AMENDMENT RECORD SHEET - LIVE APPLICATION

Application no: H22/0895/96

Description: Proposed agricultural dwelling

Amendment: Re-position dwelling inc. access drive to house to avoid
approved alignment of future access roadway

drg. no. 96901/001 Rev. A

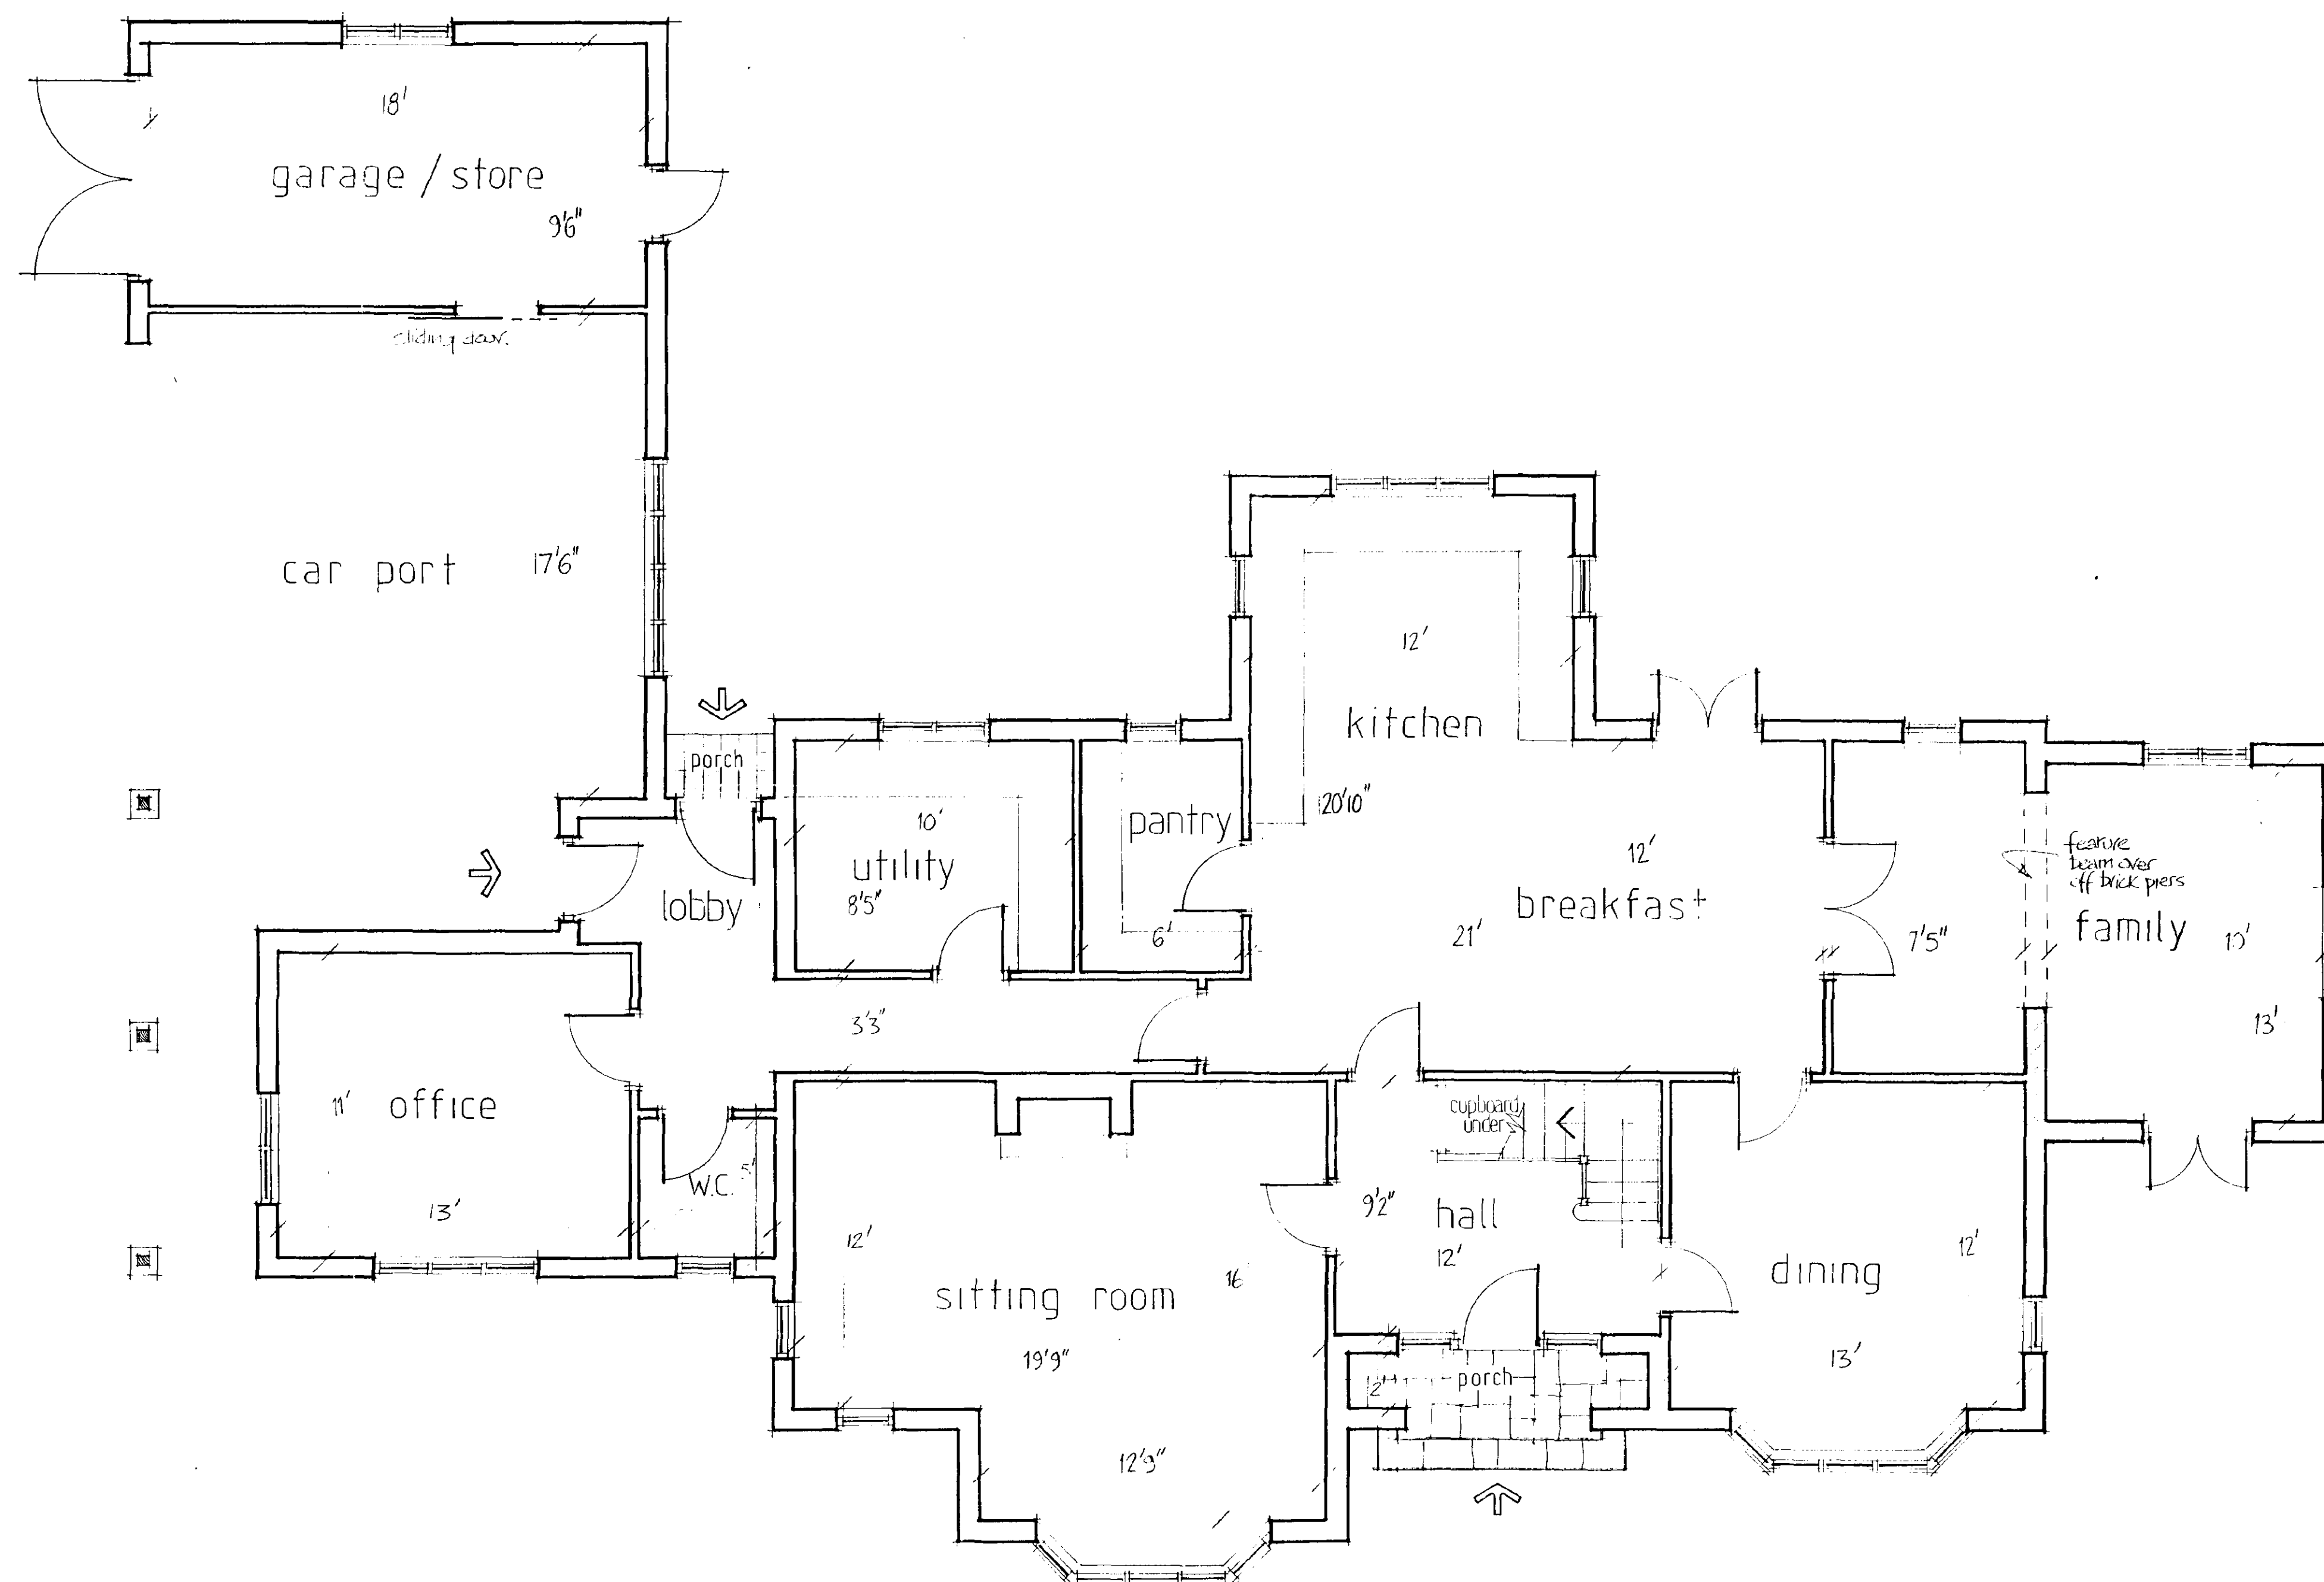
RE-POSITION PROPOSED DWELLING INC.
ACCESS DRIVE TO HOUSE TO AVOID
APPROVED ALIGNMENT OF FUTURE ACCESS
ROADWAY (APPROVED UNDER H22/0847/93).
